Martin Nugent
 01254 828060
 D3/11/1001

**Planning Application, Ribble Valley District
 3/11/1001 1 Portfield Bar, Whalley**

PROPOSED SITE PLAN

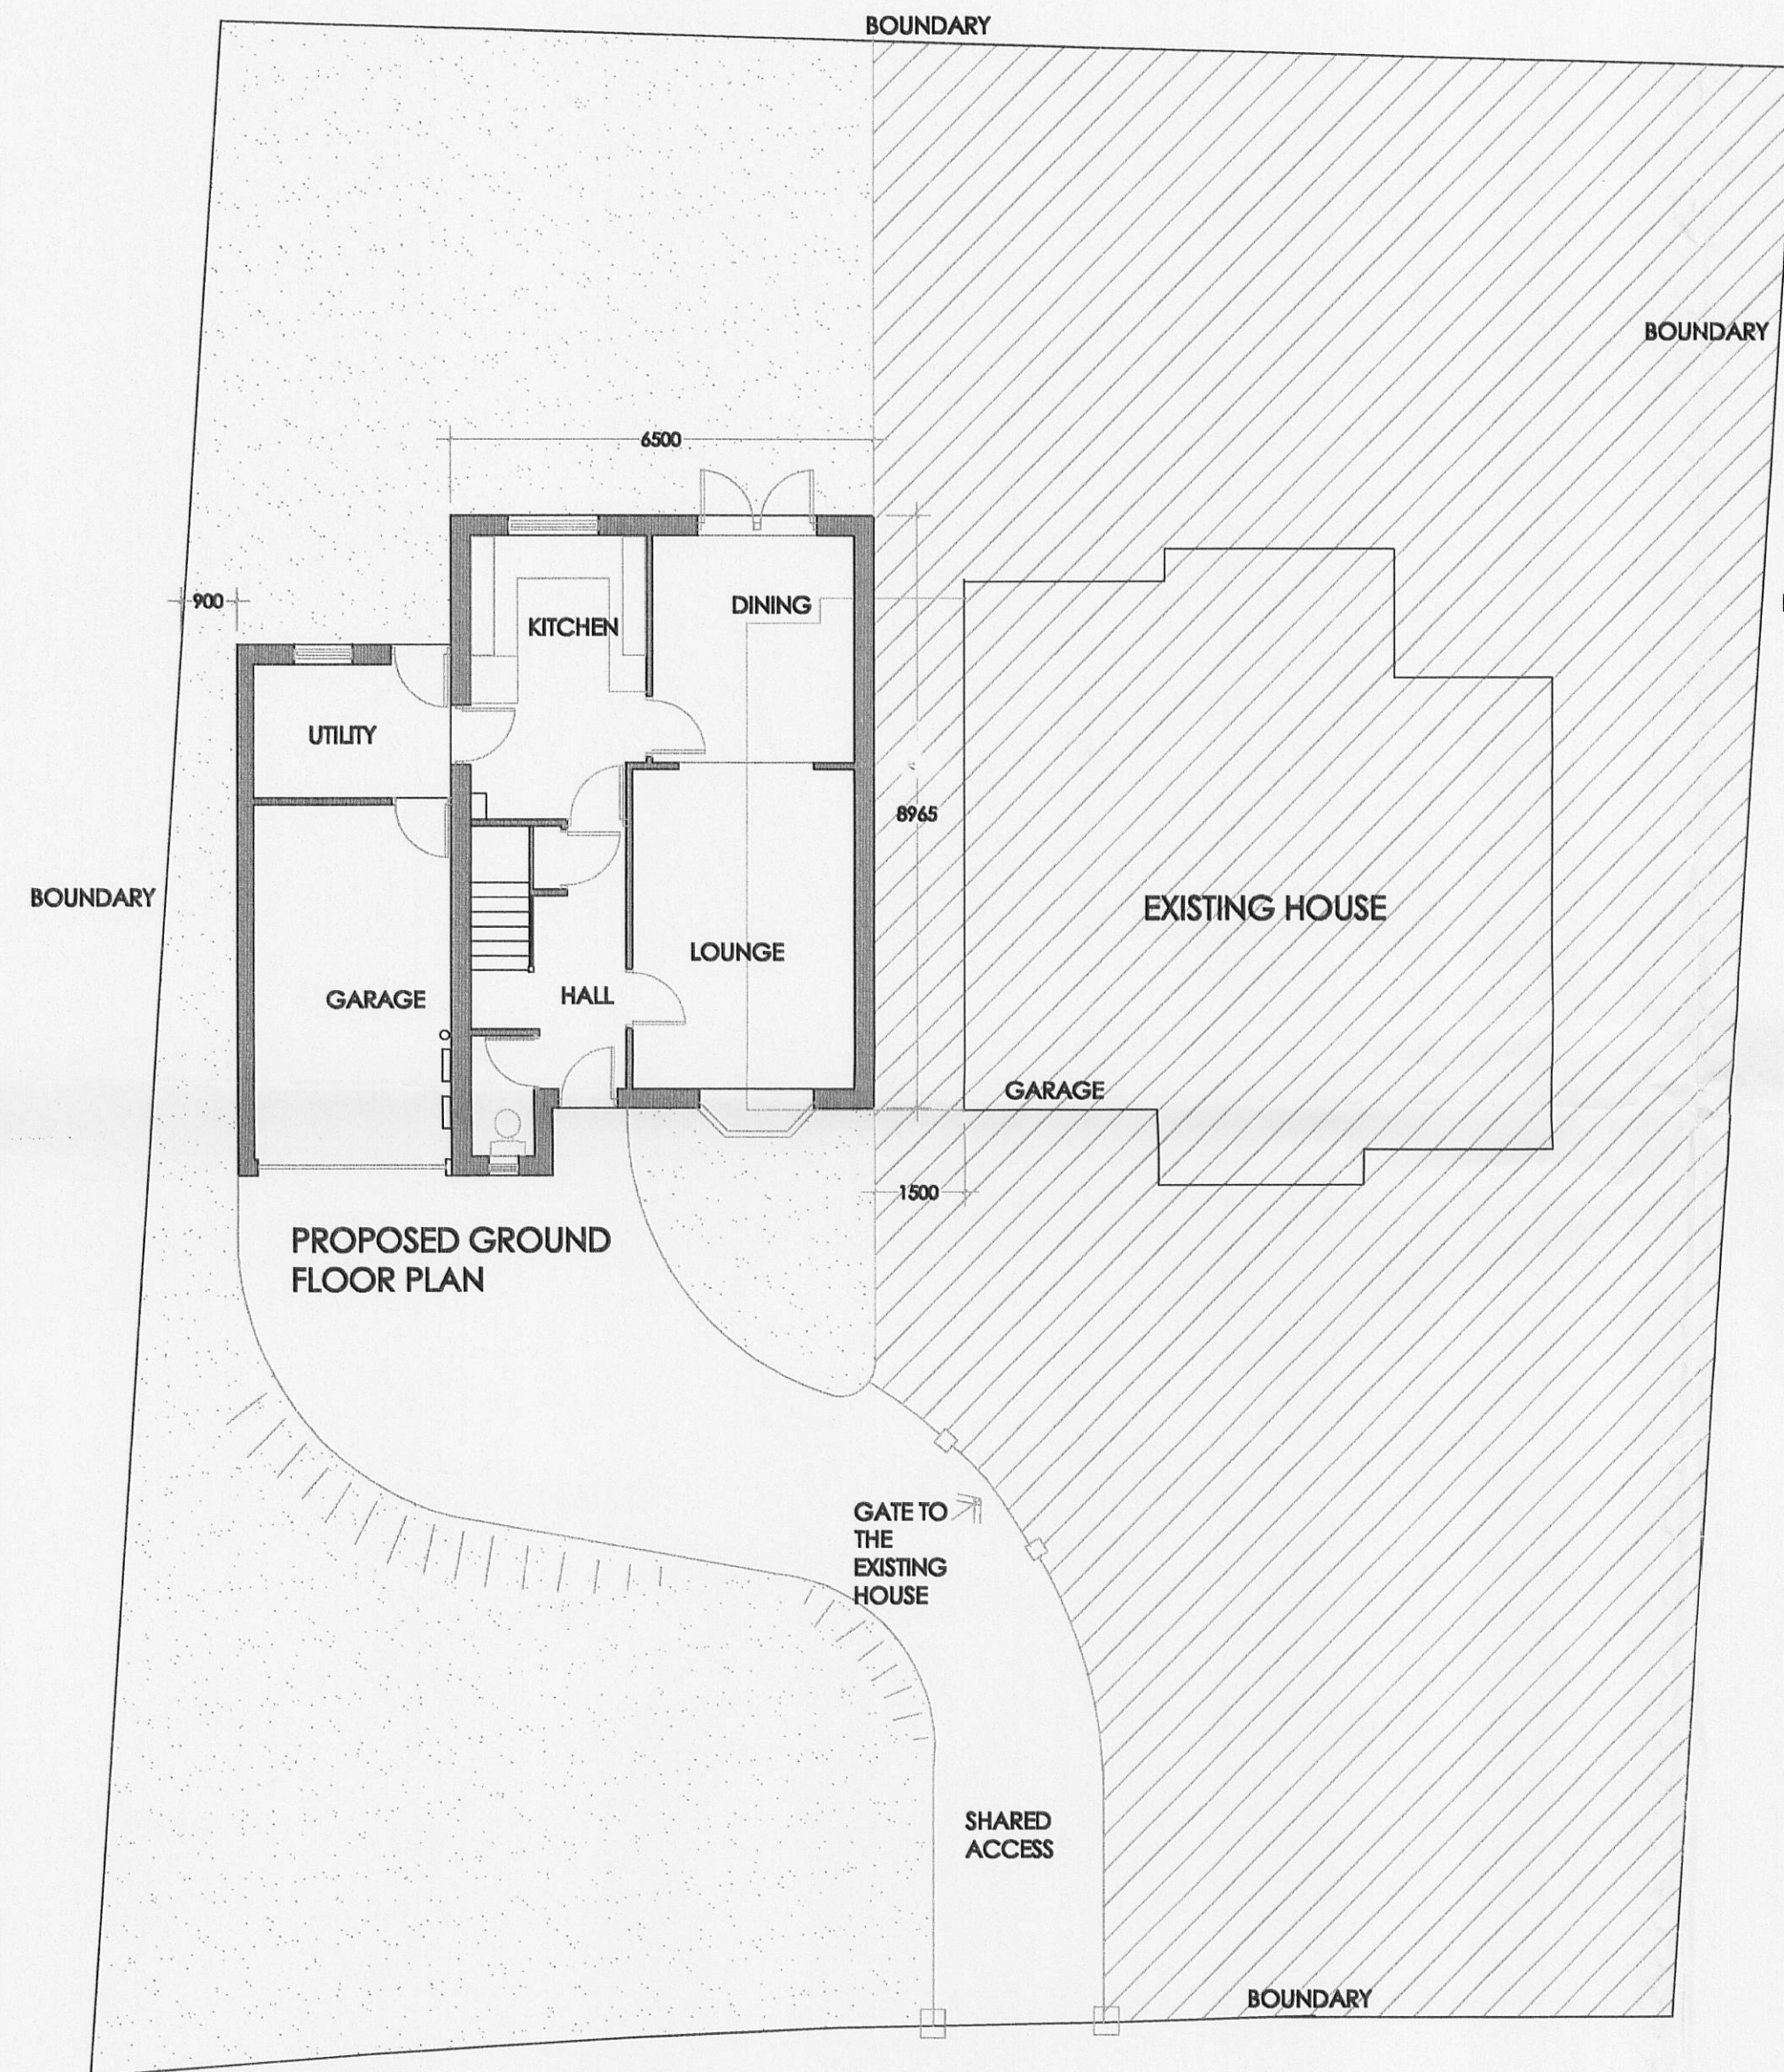
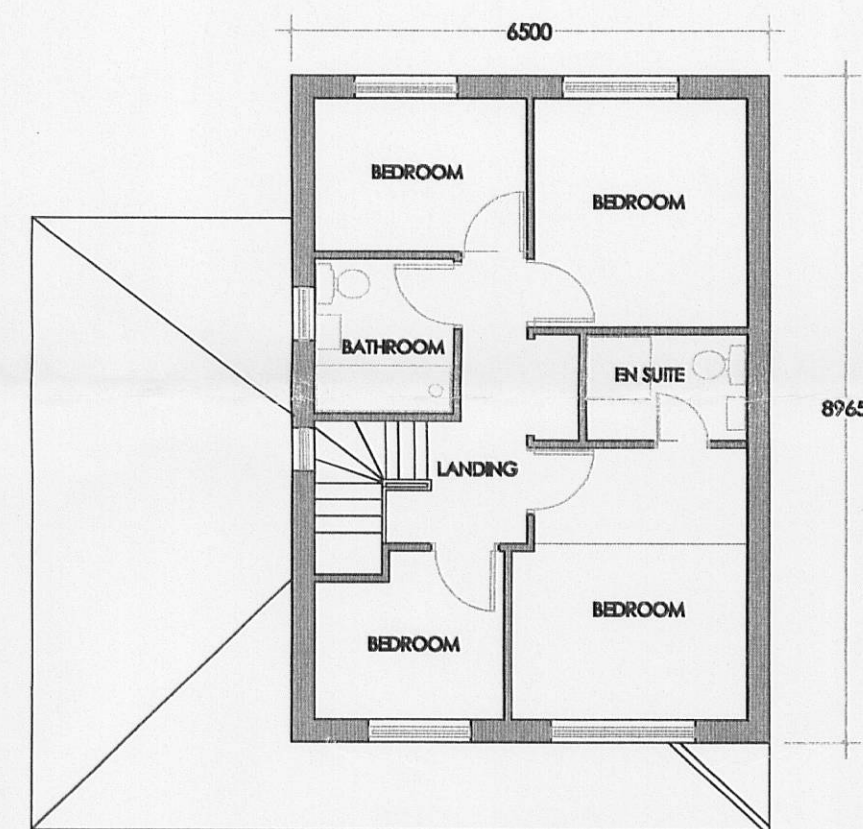
In this instance, the design must provide sufficient off street parking and manoeuvring space to ensure that all access to and from the highway can be achieved in a forward gear, as vehicles reversing to and from the highway are a hazard to other road users. The proposed design secures a minimum of two car parking spaces, consistent with a three bedroom property, but it is not clear that suitable access in a forward gear could be achieved.

Furthermore, the width of the access must allow vehicles entering the site to pull clear of the highway. The existing access is less than 3m wide and cannot accommodate shared use. A minimum access width of 4.5m is required to extend for a distance of approximately 8m, from the back of footway through to the entrance to the new development.

The widening of the access will require the provision of an additional drop kerb and associated alterations to the existing footway.

1. The proposed access from the site to A680 Accrington Road, Whalley shall be constructed to a minimum width of 4.5m and this width shall be maintained for a minimum distance of 8.0m measured back from the nearside edge of the carriageway. This is to enable vehicles to enter and leave the premises in a safe manner without causing hazard to other road users.
2. The layout of the development shall include provisions to enable vehicles to enter and leave the highway in forward gear and such provisions shall be laid out and be available for use before the development is brought into use. This

is to remove the need for reversing to and from the highway which is a hazard to other road users.

3. The kerbing at the vehicular crossing shall be reinstated in accordance with the Lancashire County Council Specification for Construction of Estate Roads, concurrent with the formation of the improved access. This is to provide the necessary access and to maintain the proper construction of the highway.
4. This consent requires the construction, improvement or alteration of an access to the public highway. Under the Highways Act 1980 Section 184 the County Council as Highway Authority must specify the works to be carried out. Only the Highway Authority or a contractor approved by the Highway Authority can carry out these works and therefore before any access works can start you must contact the Environment Directorate for further information, details below:
